CITY OF ALBUQUERQUE

December 27, 2021

**RE: The Wymont
4315 Wyoming Blvd NE
Grading and Drainage Plans
Engineer's Stamp Date: 11/02/21
Hydrology File: G19D004**

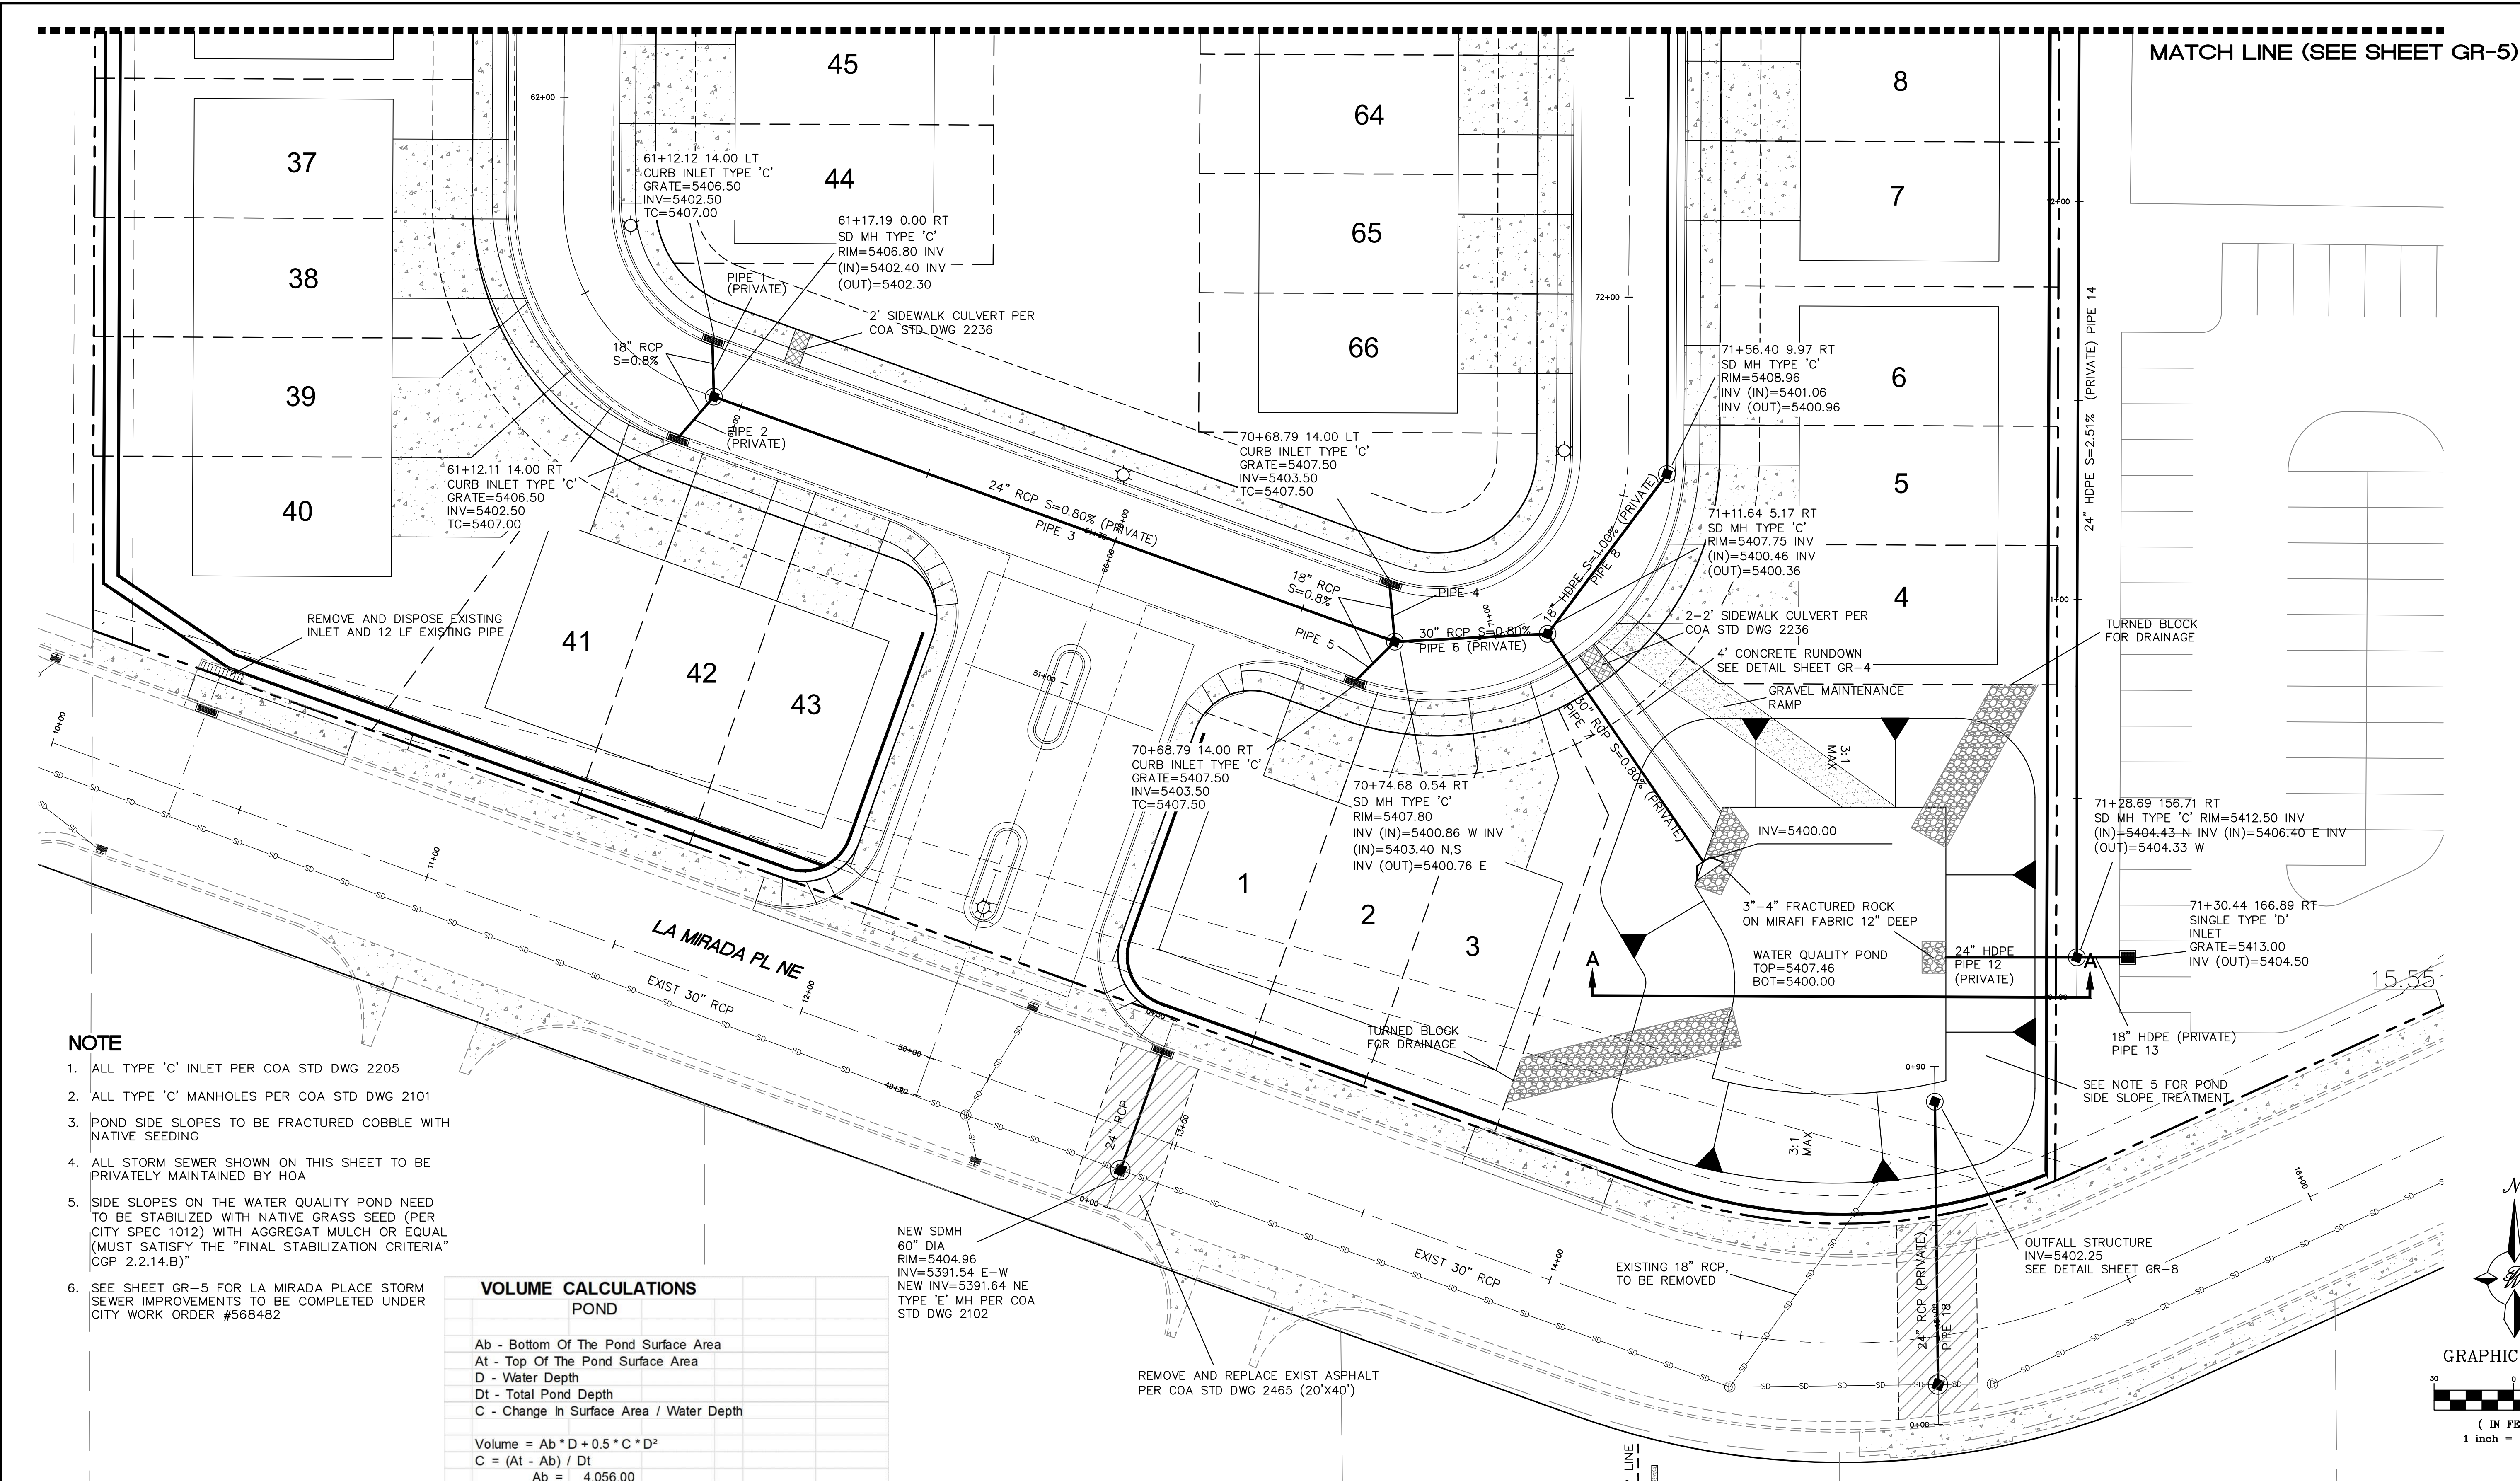
3. GR-1. This is currently very congested and difficult to read. Please, make this sheet just an overall Grading Plan with added pipe sizes, detention pond labeled, proposed contours, and line work with text showing which pipes and grading are to be done under which of the two work orders.

4. GR-1. Please add a note, "Side slopes need to be stabilized with Native Grass Seed (per City Spec 1012) with Aggregate Mulch or equal (Must satisfy the "Final Stabilization criteria" CGP 2.2.14.b.)". This is for the water quality pond.
5. Please make two Grading Plans at 1" = 20'. This will make the grading more readable and less congested.
6. GR-2. As with comment #4, this should be two storm pipe plans at 1" = 20'. Please add the word "Privately maintained" to all on-site storm pipes. This will also include the 24" RCP from the pond outfall structure to the new manhole in La Mirada Lane.
7. GR-3. Please relabel this as Master Drainage Plan.
8. GR-3. The Existing Drainage Area "A" drains to the west and then to the southwest as shown.

OUTFALL DETAIL  
NTS

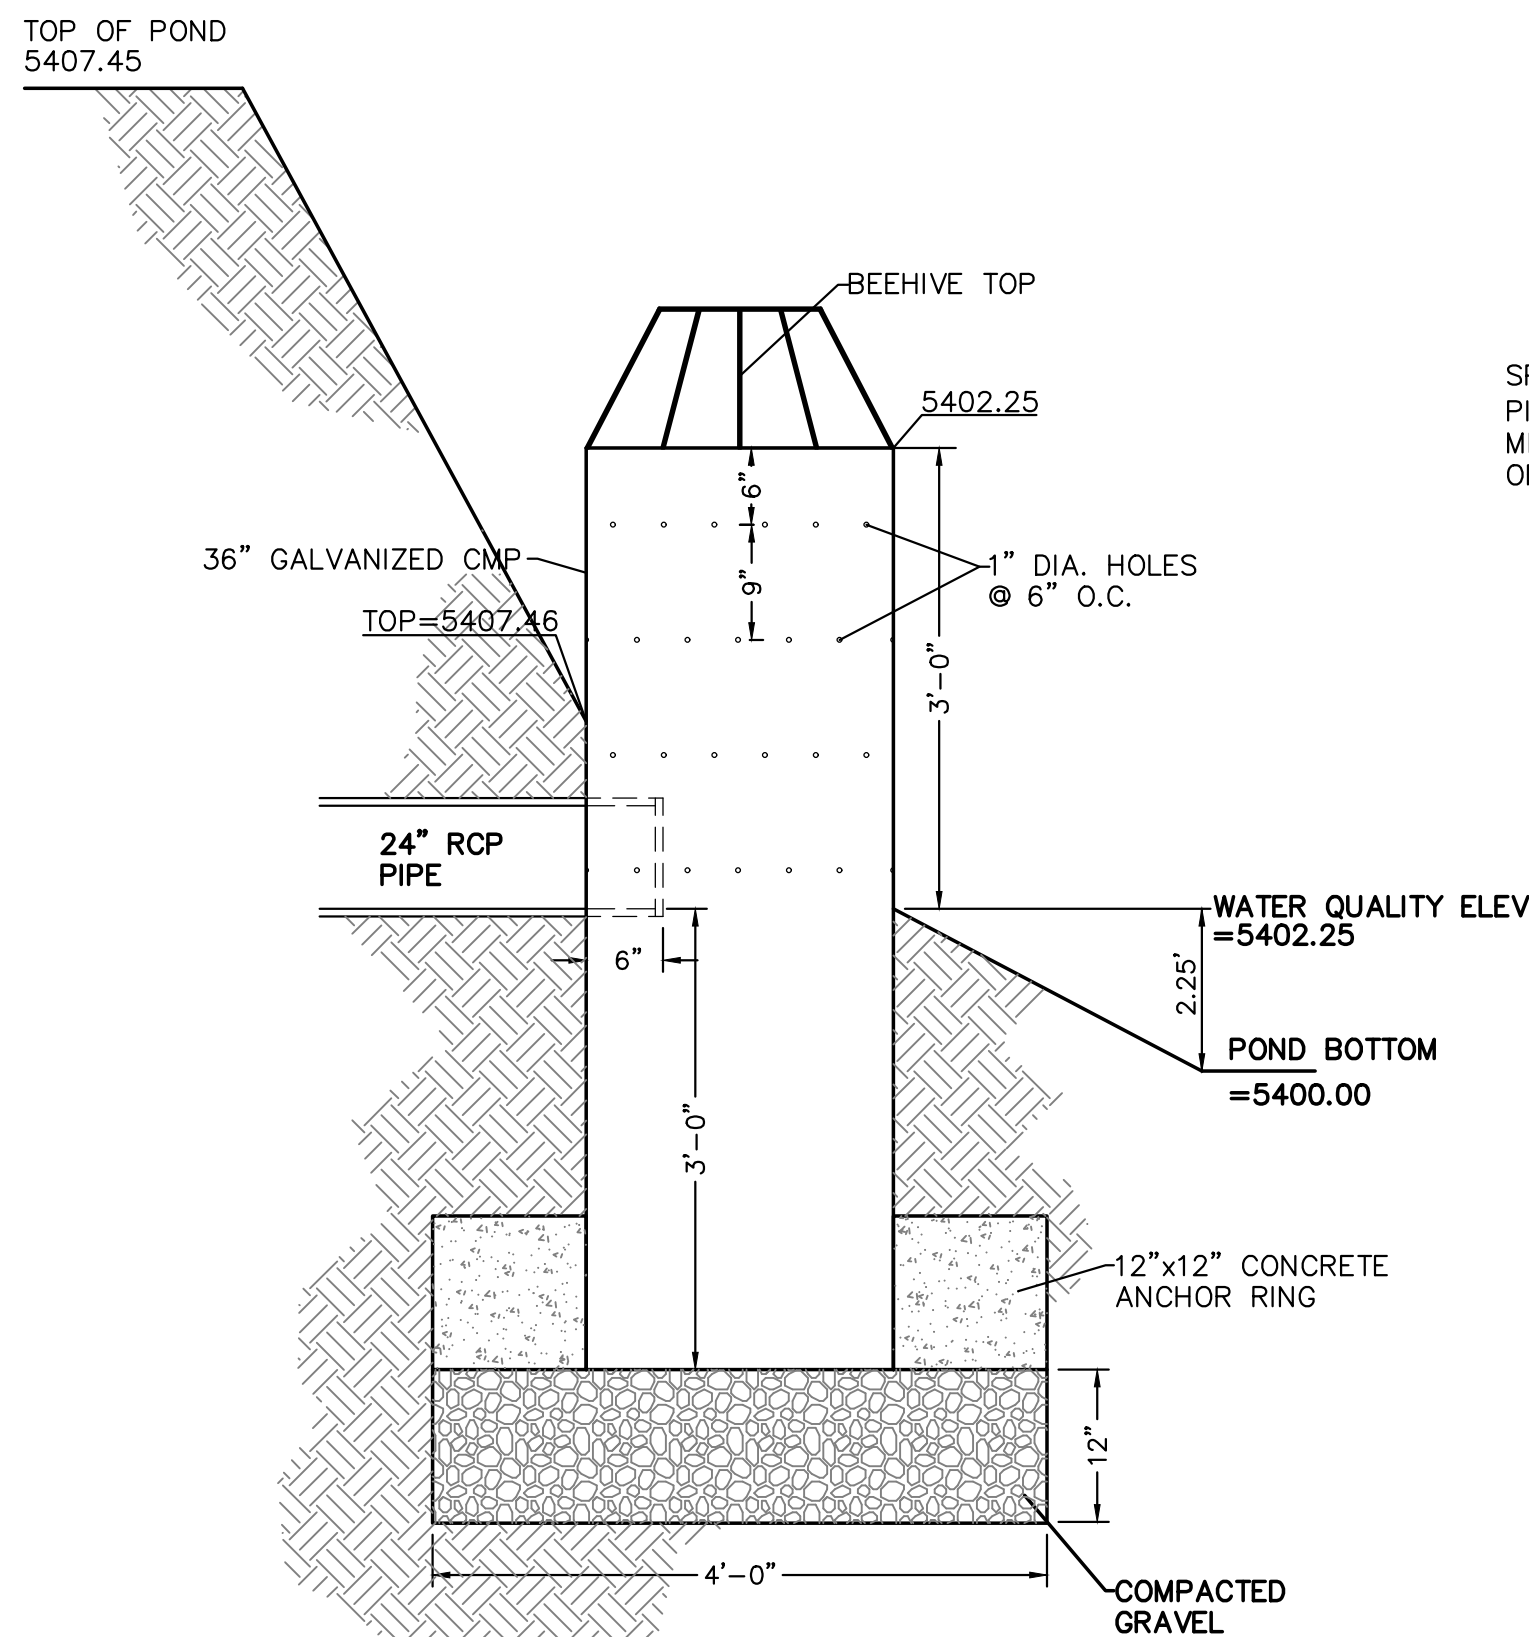
10. GR-4. Please provide the weir calculations, per DPM Article 6-16(A), for the concrete channel(s). A coefficient of 2.7 is typically used for the weir equation $Q = CLH^{2/3}$.
11. GR-4. Outfall Detail. Please provide the bottom of pond elevation, water quality elevation, top of pond elevation, and the elevation of the beehive top.

12. GR-4. Please provide the orifice calculation for the 7/8" orifice plate.
